FROM: Ian Gledhill **TO:** Arun District Council
FAO: Simon Davis

SUBJECT: P/58/15/OUT - Outline application with some matters reserved for the erection of 90 No. dwellings with associated access & open space. This is a Departure from the Development Plan.

Land at, Summer Lane, Pagham, PO21 4NG

RECOMMENDATION:

Figure 18 - Proposed Summer Lane/Pagham Road Junction

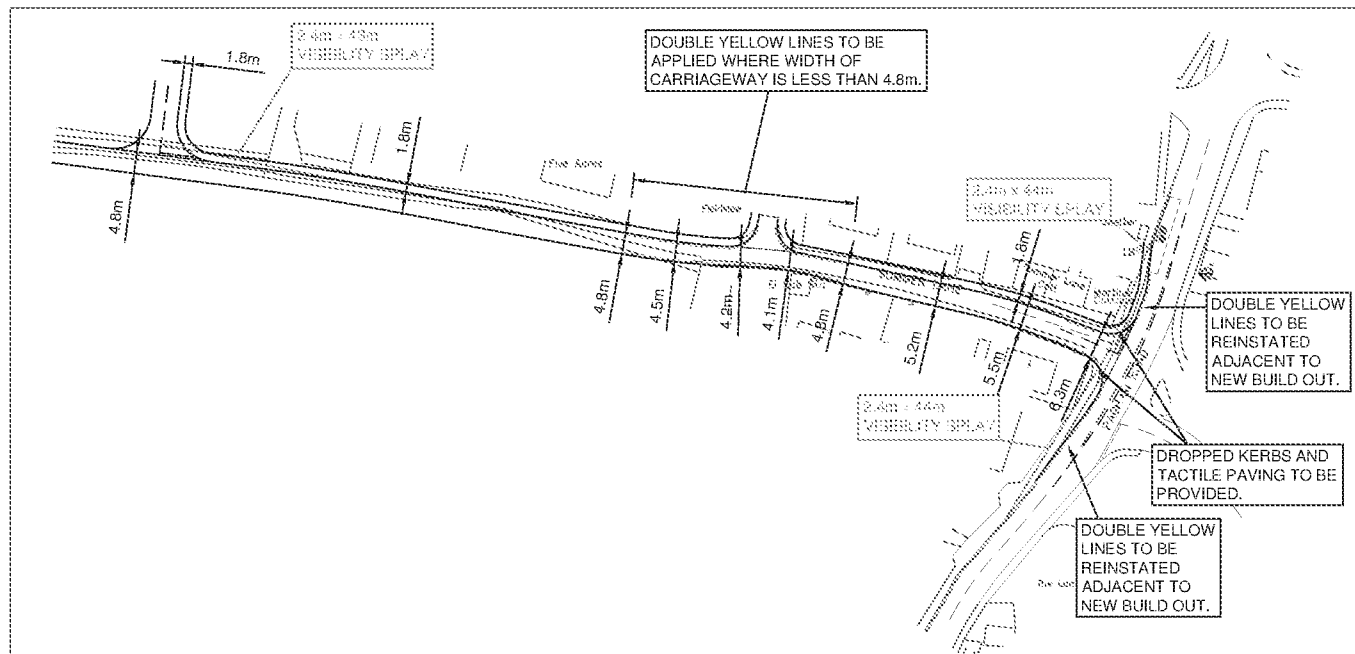
Works are also proposed to the Summer Lane/Pagham Road junction. This involves the slight realignment of the junction and the building out of the kerbline to the immediate north and south of Summer Lane to increase visibility for emerging vehicles. Whilst this narrows Pagham Road, a residual kerb to kerb width of 7.3 metres is retained. This is still adequate to enable two opposing buses or large vehicles to pass.

The second problem is in regards of visibility for northbound pedestrians on Pagham Road at the Summer Lane junction. The realignment of the junction does however reduce intervisibility between pedestrians and those vehicles exiting Summer Lane. It is acknowledged that options are limited given the visibility is primarily restricted by the fence of the adjacent property. In addressing the above problem (clearance to features), there may be the possibility of provide a narrow margin. This in turn may assist in the positioning of pedestrians crossing and visibility to oncoming vehicles. An exception report may need to be prepared by the LHA in respects of this matter if this cannot be addressed.

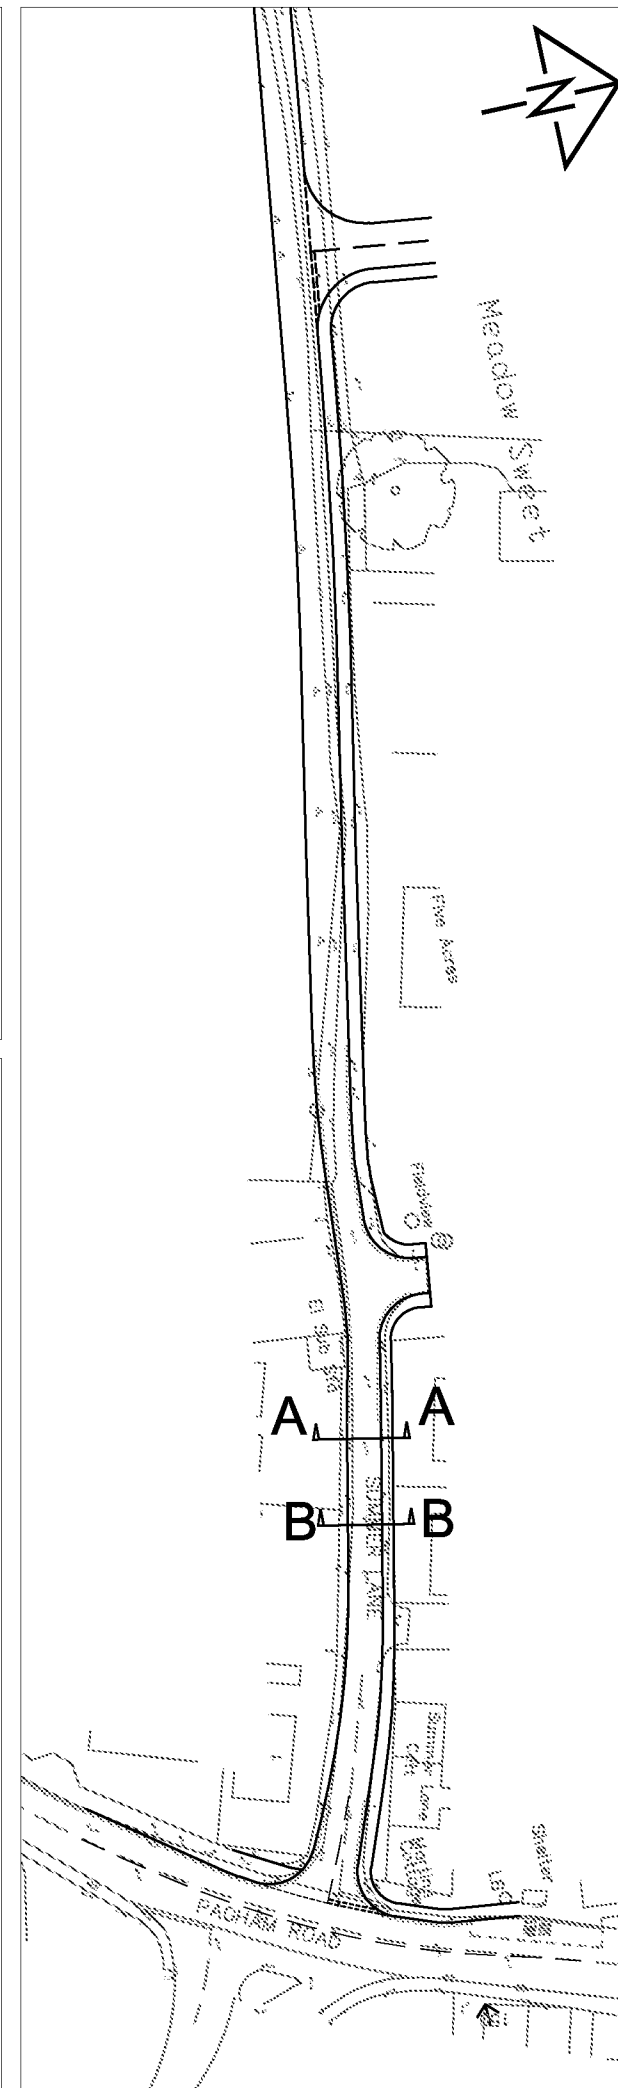
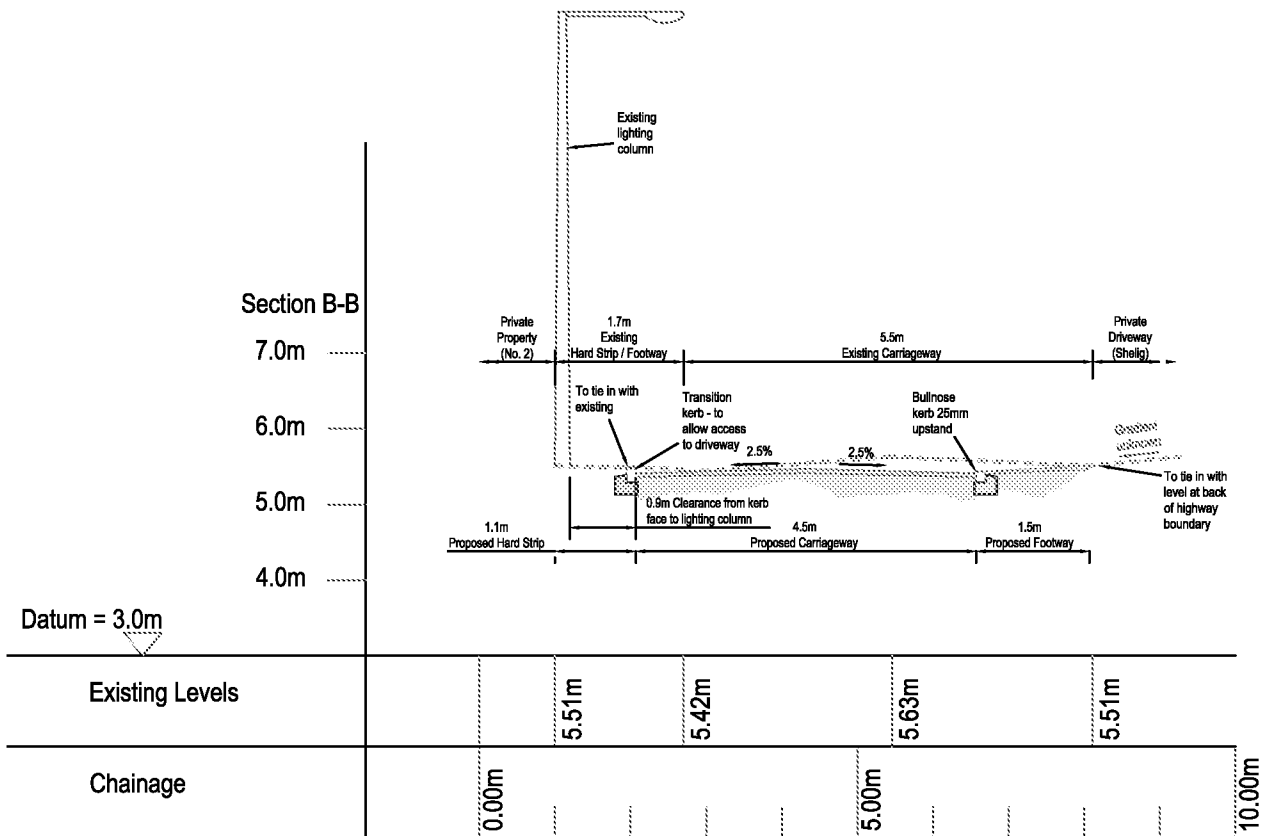
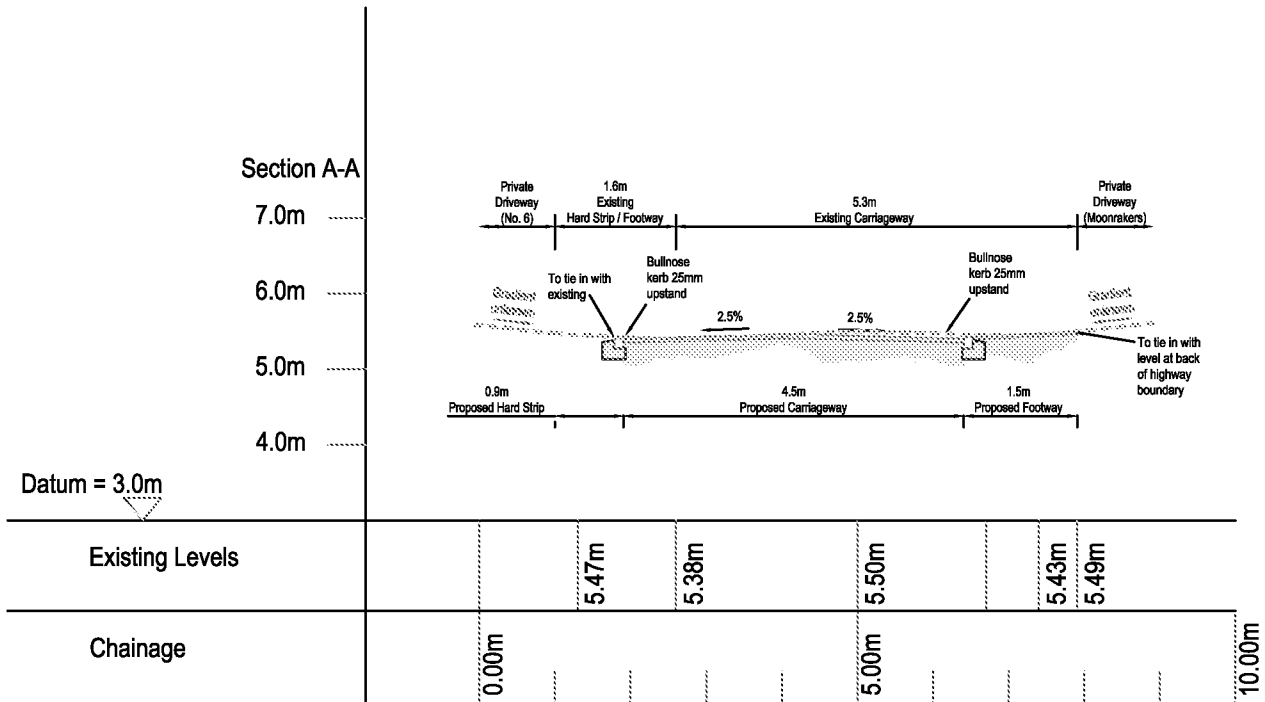
Plans are submitted showing Summer Lane being widened within the existing highway constraints and/or involving land under the control of the applicant. The works within the unadopted highway can achieve a consistent 4.8 metre carriageway and 1.8 metre footway. There are however quite a number of constraints within the adopted section.

In order to achieve a consistent 1.8 metre wide footway, the carriageway width is shown reduced below 4.8 metres over distance of approximately 40 metres. The

width would vary over this but at the narrowest the carriageway would be 4.1 metres. Manual for Streets suggests that this width is adequate to enable two cars to pass at slow speed. However this is still particularly tight. The narrowest location is also in the immediate vicinity of the eastern access.

The arrangement shown would also involve relocating the existing narrow footway from the southern side of Summer Lane to the north. In principle, there would be benefit to this given the widening of the footway that would result. Removing the footway from the southern side of the carriageway may have consequences for visibility from the accesses for those existing dwellings. It would appear that visibility may be substandard based on the existing arrangements, the proposed works would potentially worsen matters. Again, this matter should be appropriately considered with it determined how much of an impact would result from relocating the footway.

No swept paths have been provided at the access points. This is especially pertinent given the narrow carriageway width in the vicinity of the eastern access. The applicant was advised at the pre application stage to consider narrowing the proposed footway to enable localised carriageway widening. Swept paths would need to be provided and the carriageway width revisited accordingly.

No waiting restrictions are shown in the immediate vicinity of the eastern access. Waiting restrictions will be the subject of a further statutory consultation process. As such the outcome cannot be guaranteed. The proposal would need to be shown as deliverable in the event that the traffic regulation order process failed.

There is also a potential issue relating to the build-ability of the footway arrangement as shown. There is quite a notable gradient on the driveways of the two properties, Moonrakers and Shelig. The gradient on both falls towards Summer Lane with the cross fall of Summer Lane appearing to fall towards these properties. The construction of a footway on the north side of Summer Lane would involve the building up of the carriageway to create a segregated arrangement. Due to the gradients on the driveways it's unclear how the driveways would then tie into the footway without resulting in a significant step from the private driveways onto the footway. Alternately, works would be required to the driveways of both properties that lie outside of the control of the applicant and the LHA. It's suggested that a cross section is provided showing the ability to provide the footway in light of the existing driveway gradients.

The first relates to clearance to boundary features on the southern side of Summer Lane with the proposed scheme including no margin to existing features. It is normal practice to provide clearance of 450mm (300mm absolute minimum) to features alongside the carriageway to ensure these are not struck. Such clearance would appear achievable in certain locations where the carriageway widens to over 5 metres. The designer is recommended to revisit the design to determine if a margin

can be provided along the southern side of Summer Lane. Depending on the outcome of this, the LHA may need to consider an exception report.
